CITY OF ALBUQUERQUE

April 12, 2019

Re: Disco Central LLC
3123 Central Ave NE 87106
Traffic Circulation Layout
Engineer's/Architect's Stamp **03-01-2019** (K16D201)

Sheet: Traffic Control Layout

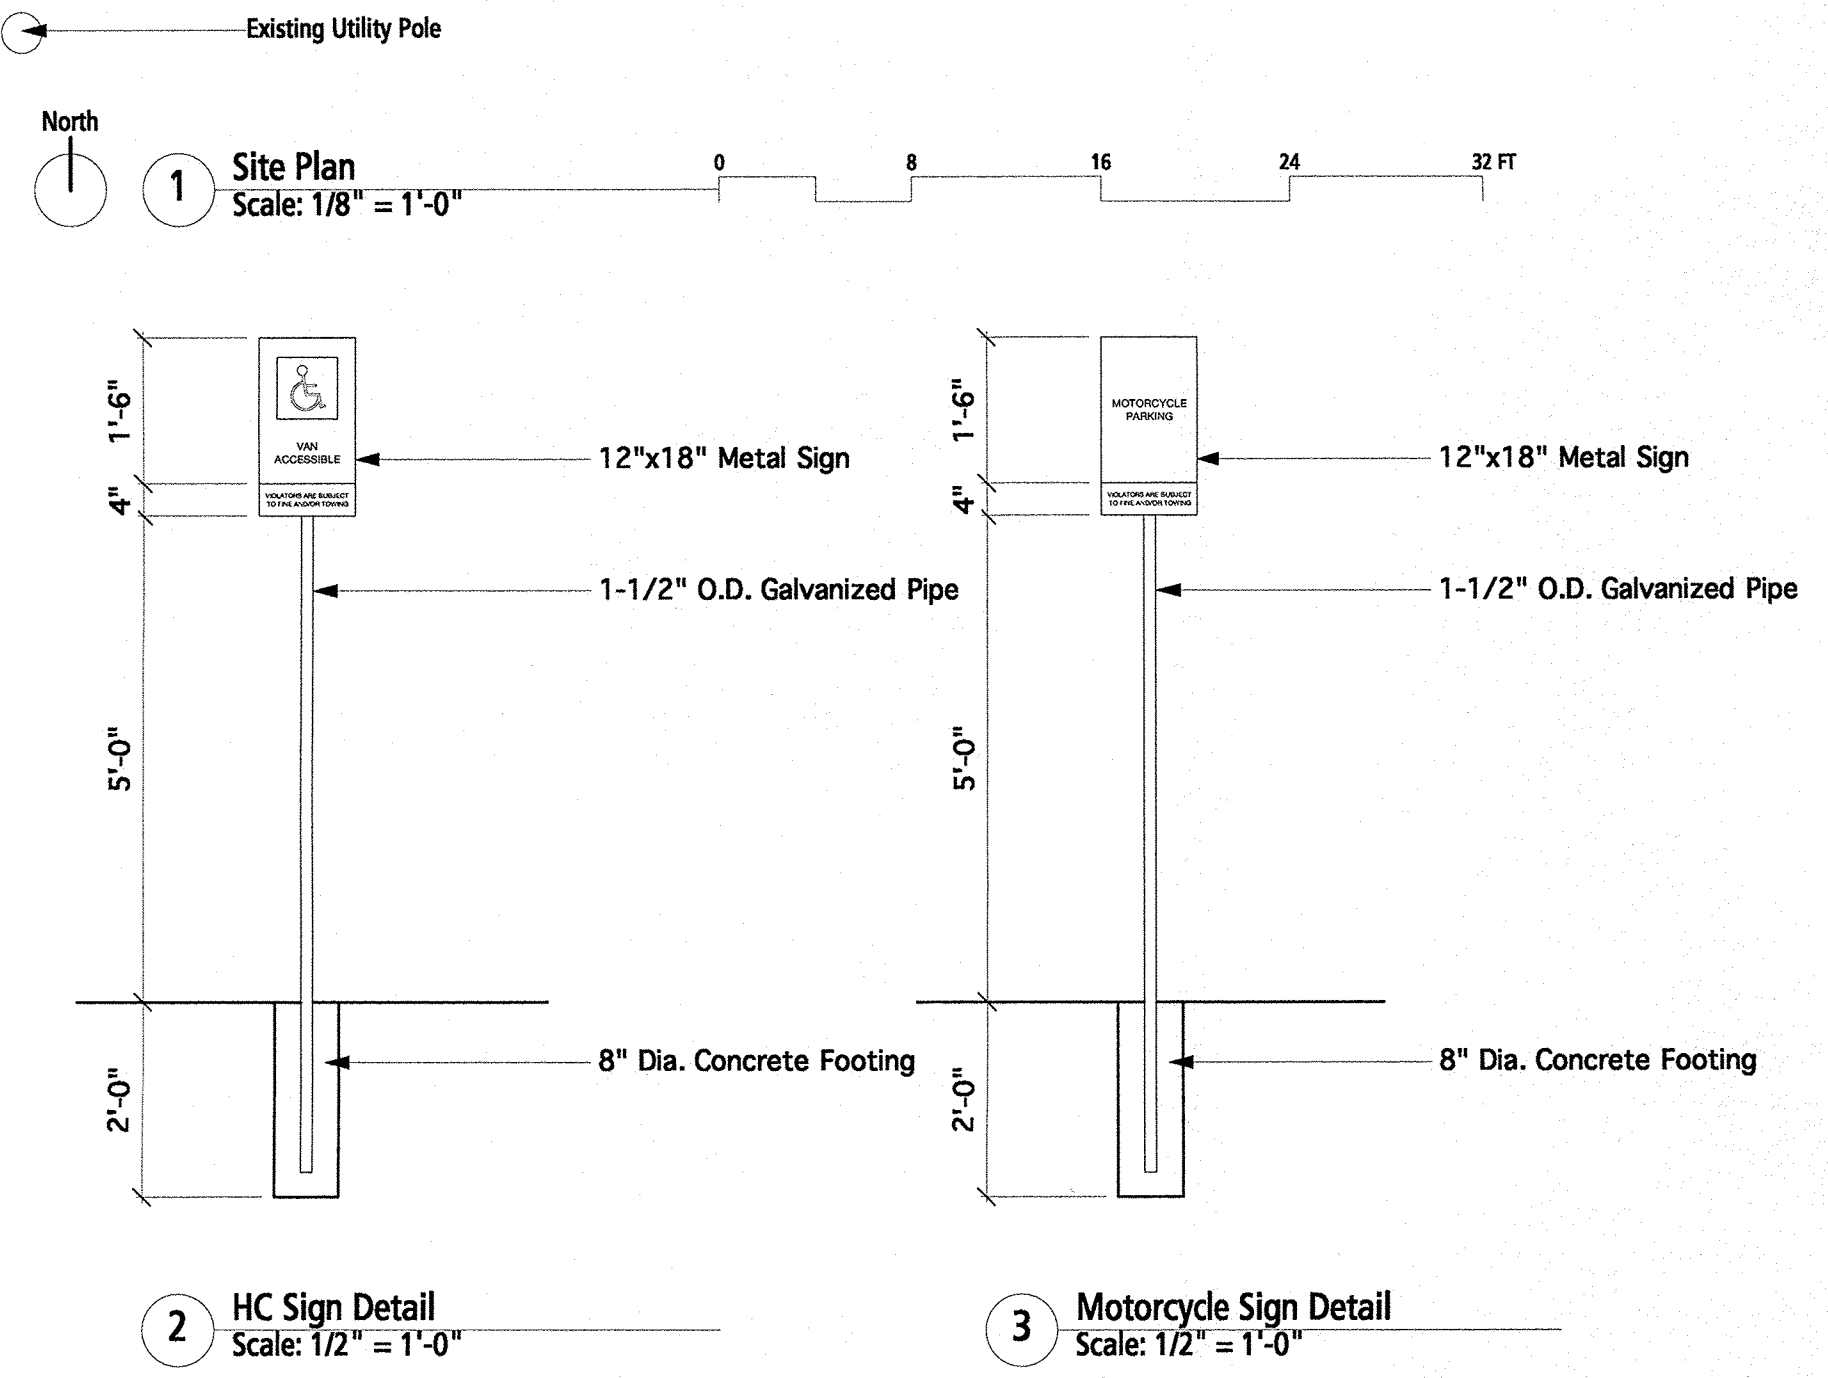
1. Service vehicle and/or refuse vehicle maneuvering must be contained **on-site**
